25 February 2022

Your Ref: SSD 6964 MOD 4, SSD 6965 MOD 5 & SSD 8892218 MOD 1
Our Ref: R/2016/35/G, R/2020/13/D & R/2015/36/G
File No: 2022/075983

Advice on Response to Submissions– Barangaroo South – Building R4A – SSD 6964 MOD 4 and Building R4B – SSD 6965 MOD 5 and SSD 8892218 MOD 1

2.2 Landscape amendments at the ground plane

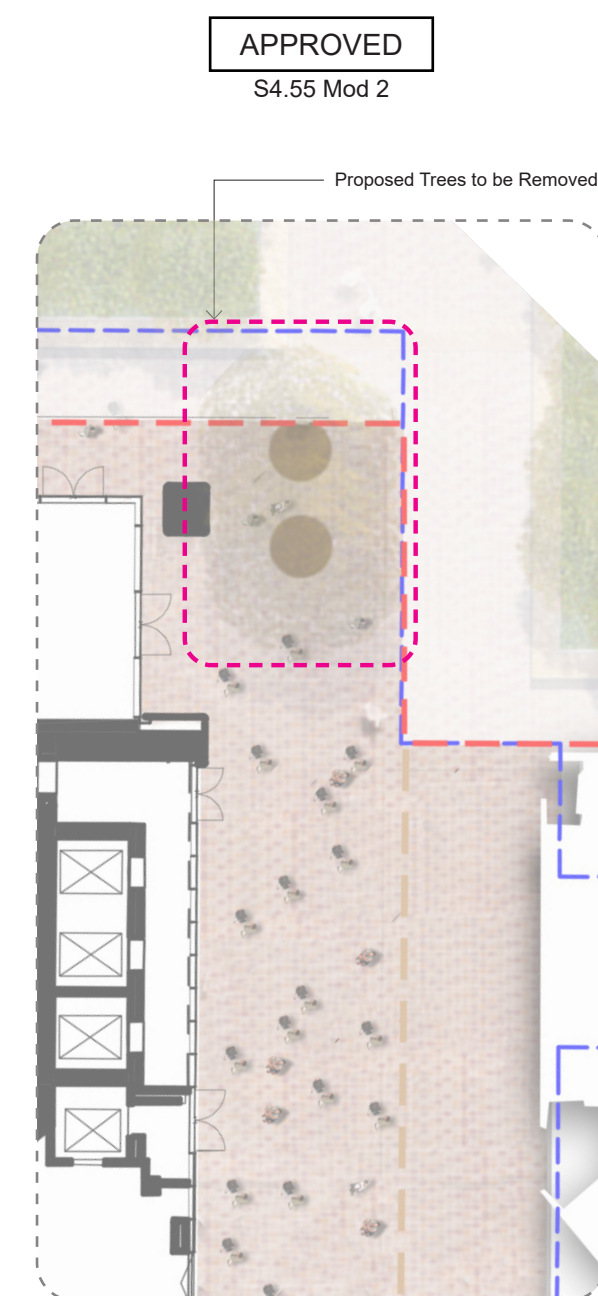
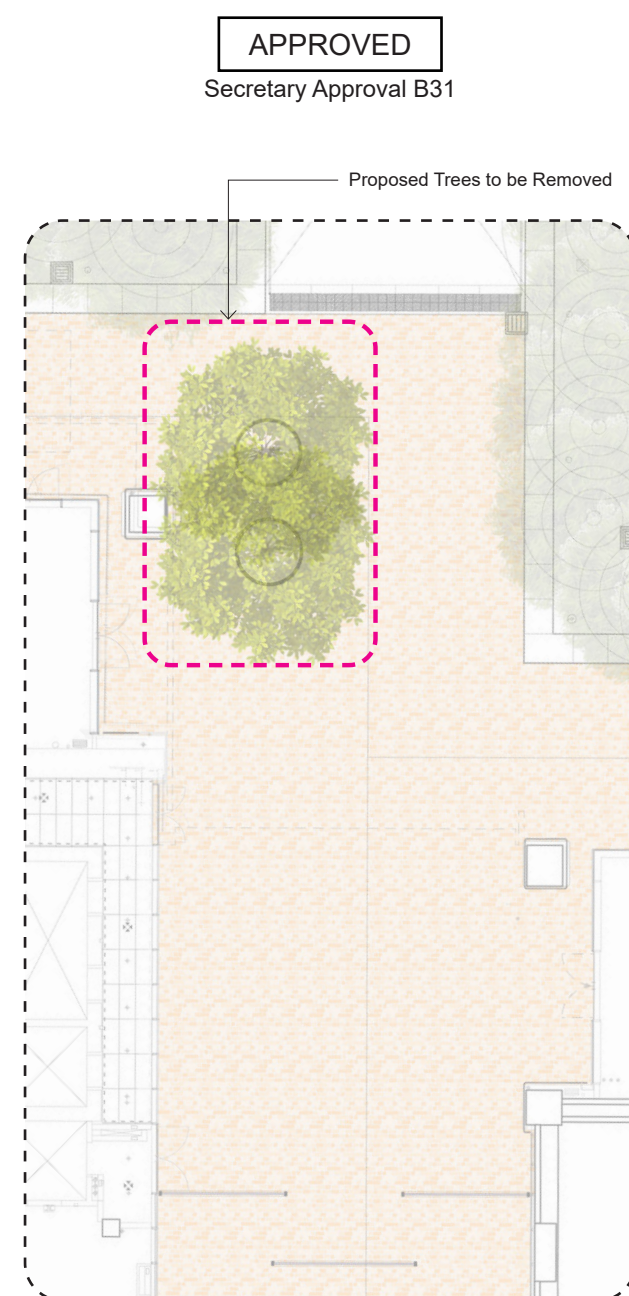
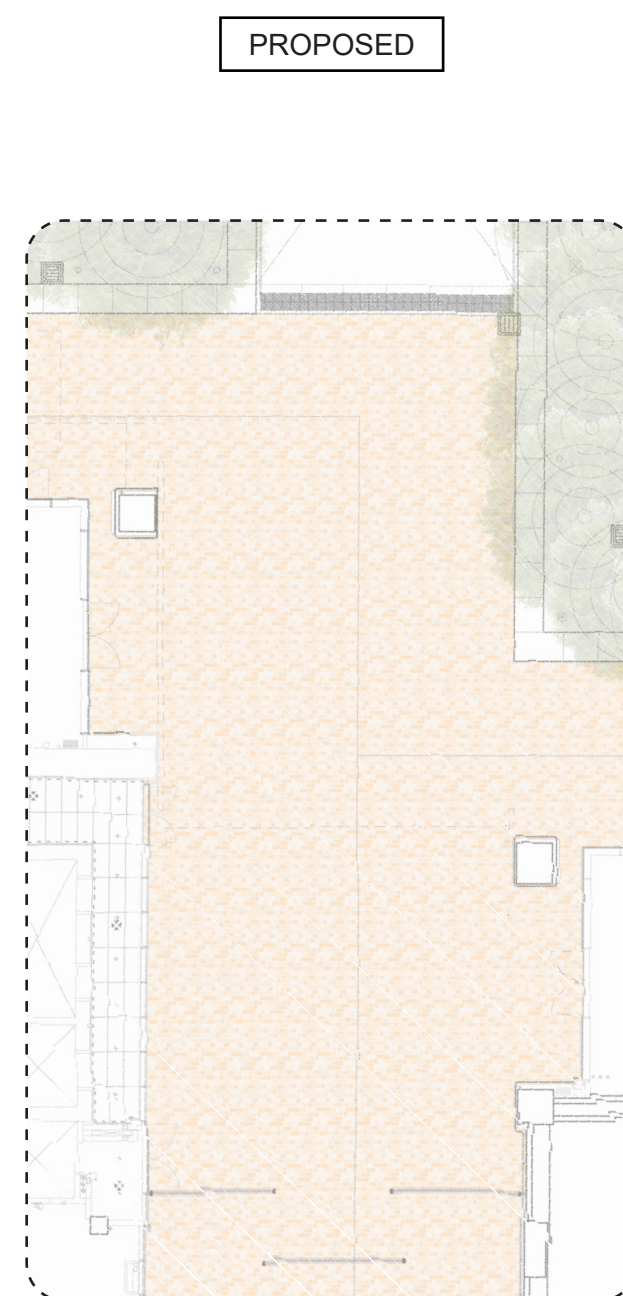
The City also notes submitted RtS response to application SSD 6964 relating to Building R4A in regard to the proposed removal of two trees adjacent to the ground floor commercial tenancy fronting Hickson Park. The submitted RtS notes that the two approved trees adjacent to the ground floor tenancy sightlines to the entrances of Building R4A and general navigation and wayfinding through the site and impede view corridors along the Strada between buildings R4A and R4B.

The City maintains that any removal of future canopy coverage should be reconsidered as the benefits of additional canopy to pedestrian amenity outweigh potential view impacts, particularly in relation to wind protection and shading in addition to general heat mitigation. Impacts on sightlines, navigation and general view corridors are considered

negligible, particularly as other trees are approved for planting at the southern end of the Strada and adjacent to other commercial tenancies.
